PLANNING DEPARTMENT
July 16, 2014
DRB Comments

PROJECT # 1010162

APPLICATION # 14-70234

RE: Block 9, Huning Highlands Addition

PROJECT: 1010162
DATE: 7-16-14 (SK)

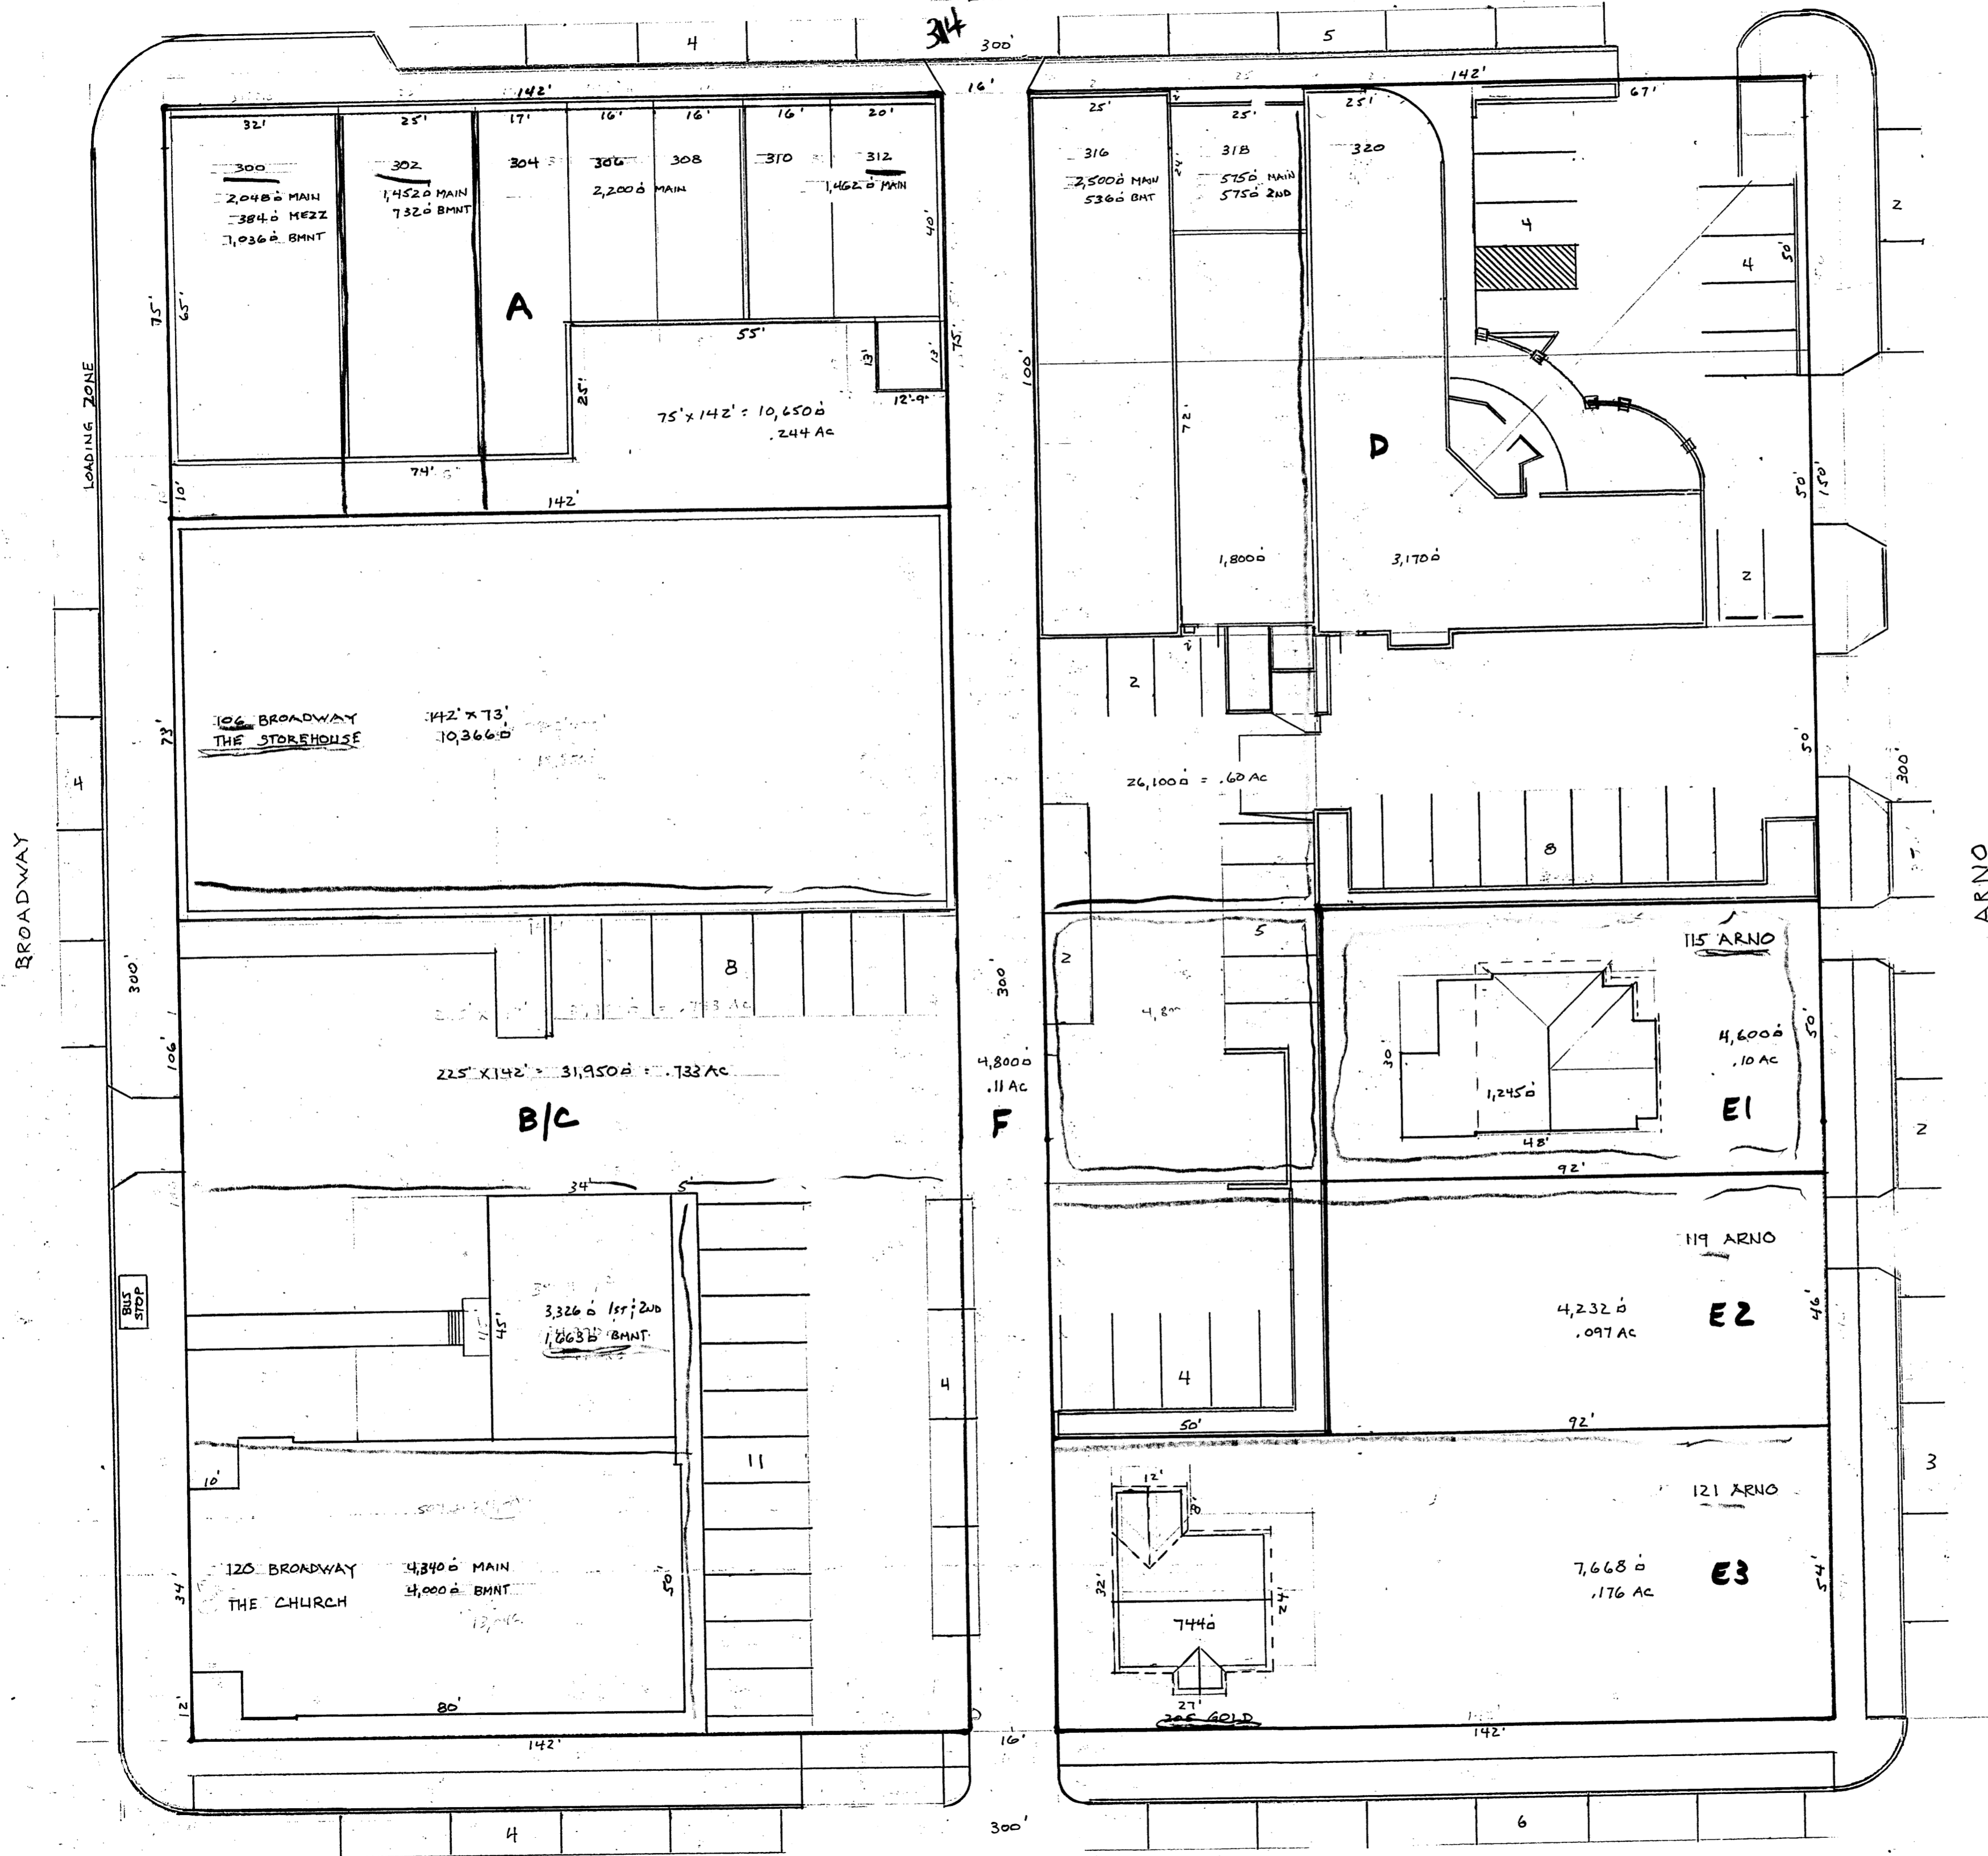
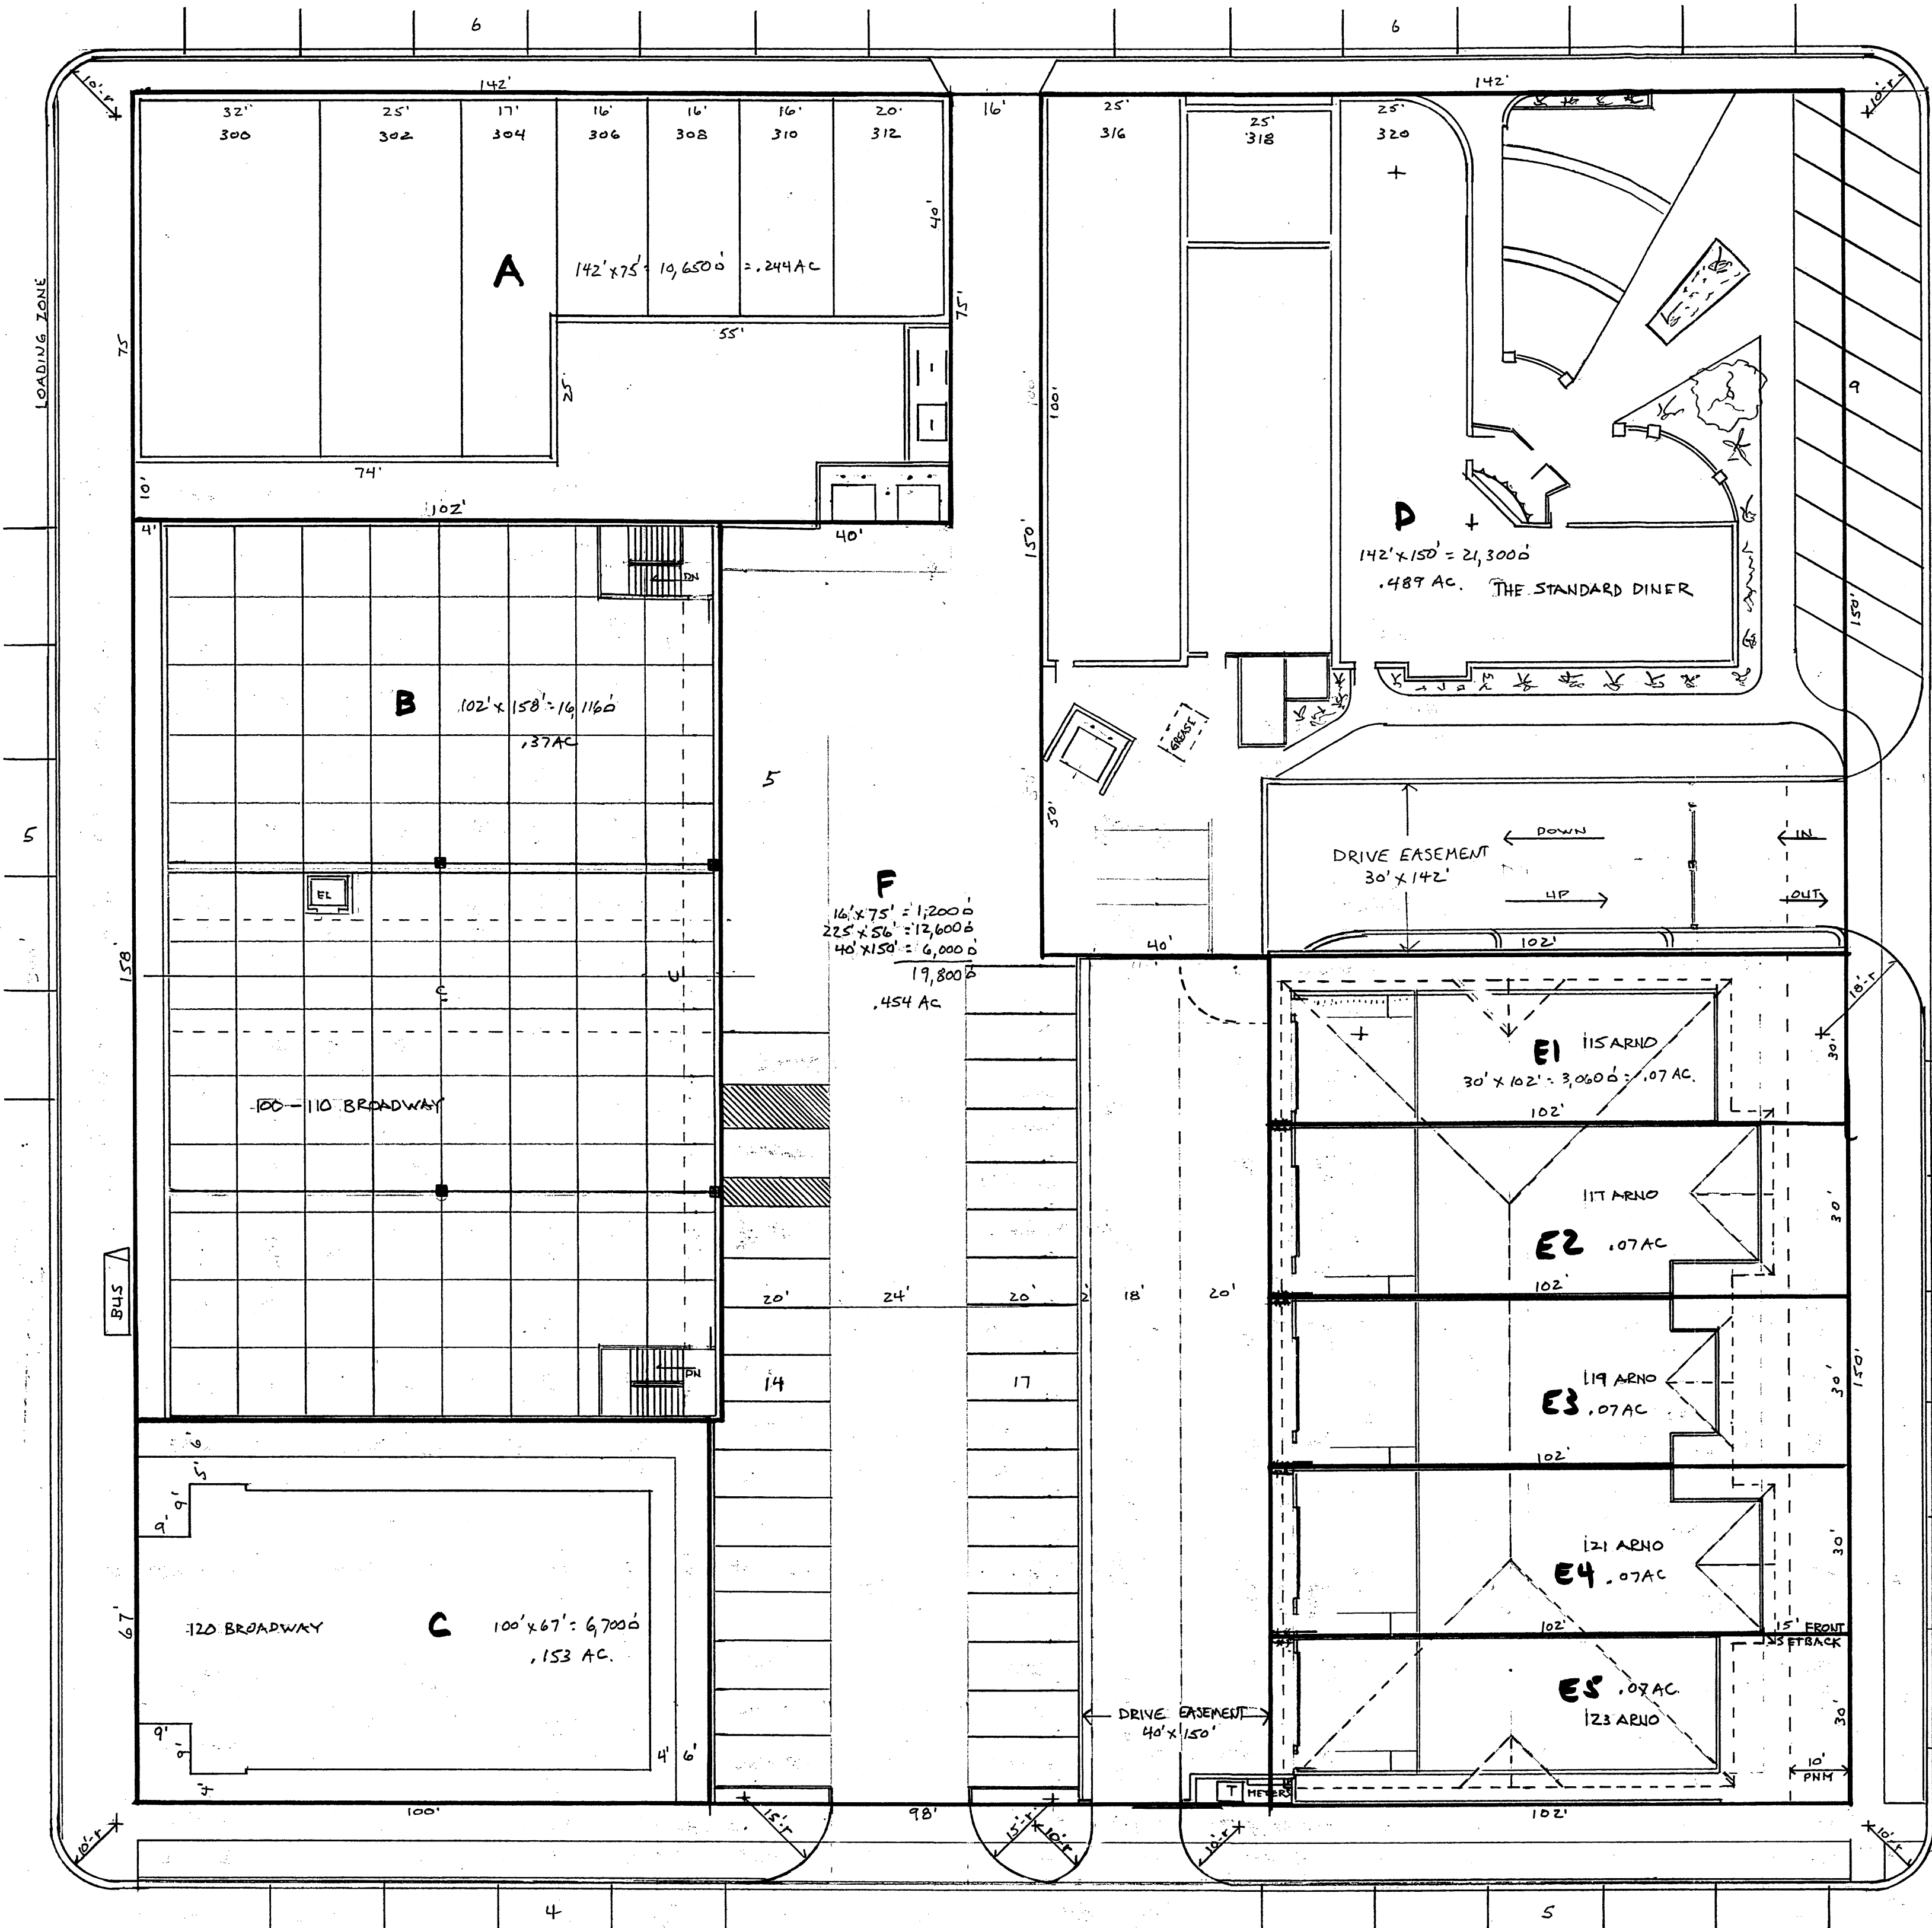
The full alley would have to be vacated and acquired and replatted into adjacent property; City Council approval of the vacation would be required after a public hearing and recommendation by DRB.

An underground parking garage would need to be on its own lot (combine B, F, and portion of D) to comply with the Building Code; easements could allow for parking and / or access to benefit other lots. Alternatively, the block could be platted with all CRZ tracts combined as a single lot and have area divided as condominiums. As noted in PRT, a Conditional Use Permit would be required for proposed townhomes in SU-2/ MR zone; access easement will be needed for rear garages.
